Our Reference: PA-0004779/03
Customer reference: 3/2026/0238
Date: 19 August 2026

Approval of details reserved by conditions 3 (construction management plan/method statement) 4 (surface water) 5 (bat boxes) 7 (street maintenance) 8 (flood mitigation) 9 (flood management plan) 10 (surface water/foul drainage) 19 (cycle storage) 20 (travel plan) and 21 (operation/maintenance manual) on planning permission 3/2022/1158 granted on appeal APP/T2350/W/25/3368139.

Land South of Accrington Road, Whalley

Drawing file: planx_downloads / 26_0238_AMENDED_290726_Flood_Comp_Storage_Sections_2.pdf

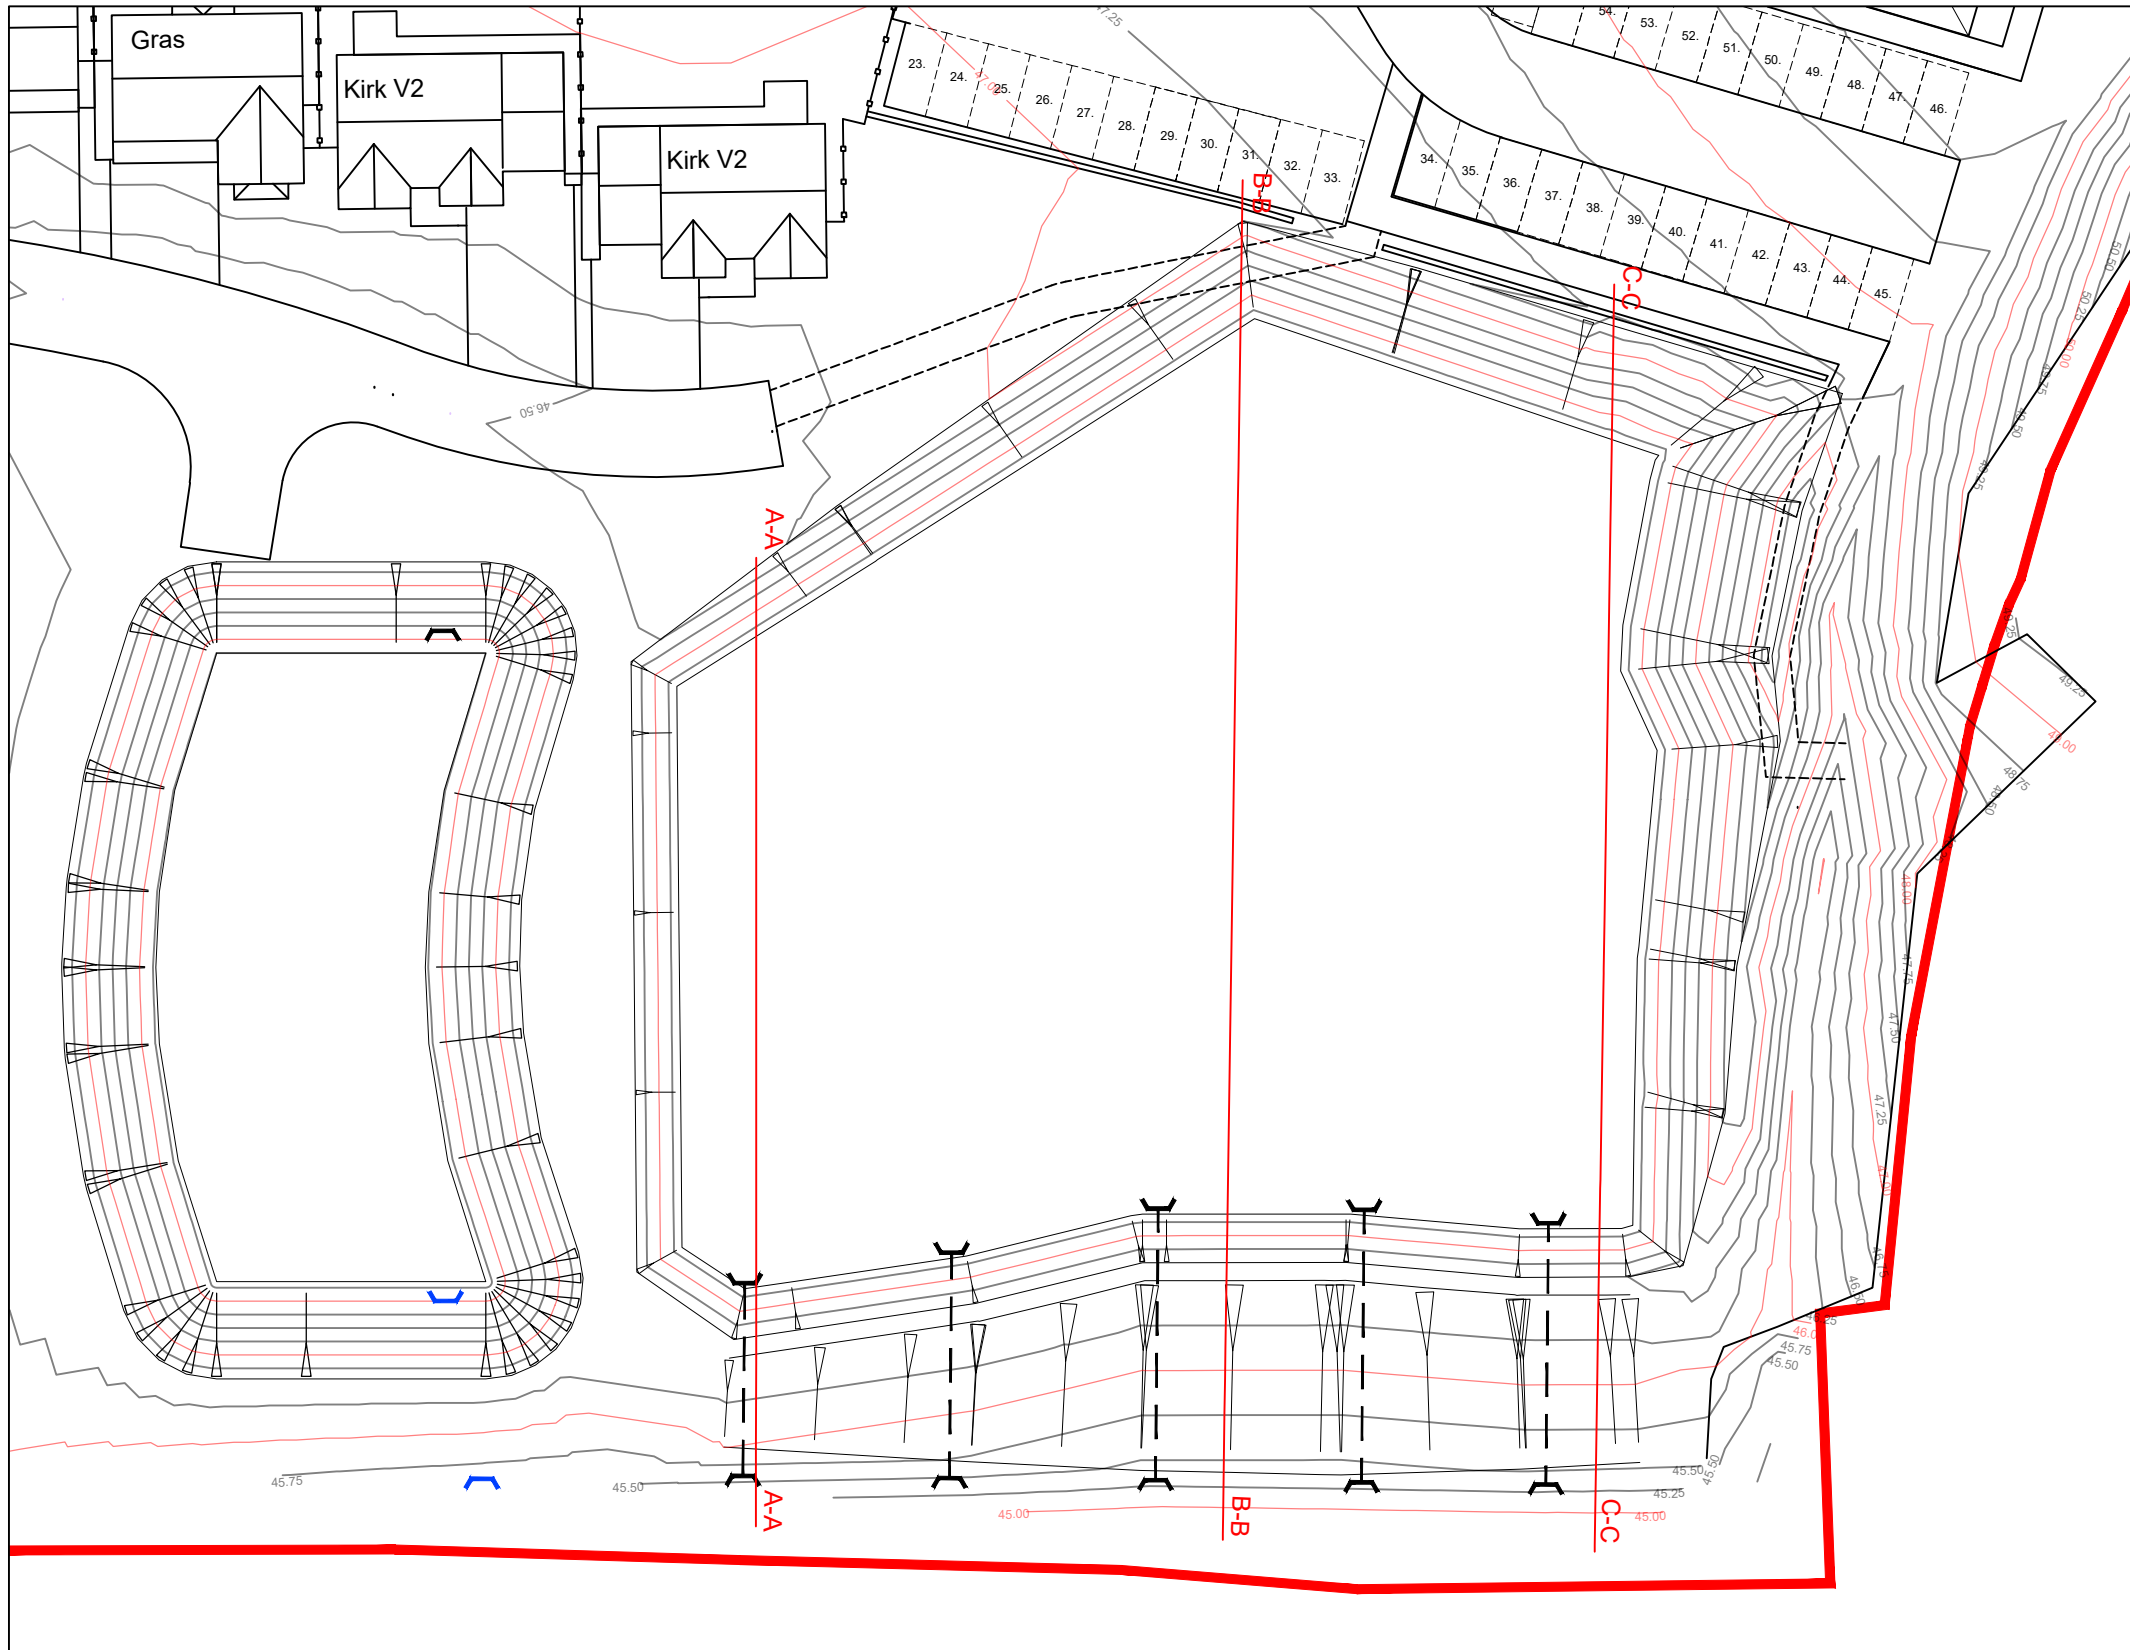
Whilst additional information has been provided, we do not consider that sufficient detail has been submitted to demonstrate the final engineering solution required by

Condition 8. In particular, further clarification is required regarding the detailed design solution and the provision of proposed construction cross-sections in proximity to the River Calder, which is designated as a Main River and forms the southern boundary of the site.

There remains insufficient information to demonstrate that suitably engineered, stable, and maintainable ground conditions will be provided, particularly in areas where works are proposed over or adjacent to the five Flood Compensation Area (FCA) culverts. Furthermore, in the absence of this information, it is not possible to determine whether adequate consideration has been given to future access arrangements and maintenance requirements.

The engineering concerns outlined above relate to the area of land between the River Calder and the site. This area includes the retaining embankment for the compensatory flood storage area and is perforated by 5 no. 450mm diameter fill/drain down outfalls.

Insufficient information has been submitted to demonstrate the provision and retention of a suitably engineered 8-metre-wide access corridor. This would facilitate access by appropriately sized medium and heavy plant to the weir, should such access be required for the removal of debris blockages, reactive repairs, or future improvement works.

support the proposed works, particularly in relation to the interface with the River Calder and the FCA culverts.

Please refer to our previous letter and the points highlighted above and address the matters systematically, paying particular attention to the proposed construction details forming the area of land between the River Calder and the site.

This should include sufficient information to demonstrate how the full 8-metre access corridor adjacent to the Main River will be retained and maintained for the lifetime of the development and how this can be achieved without compromising the integrity, operation, maintenance and long-term functionality of the compensatory flood storage scheme and associated infrastructure.
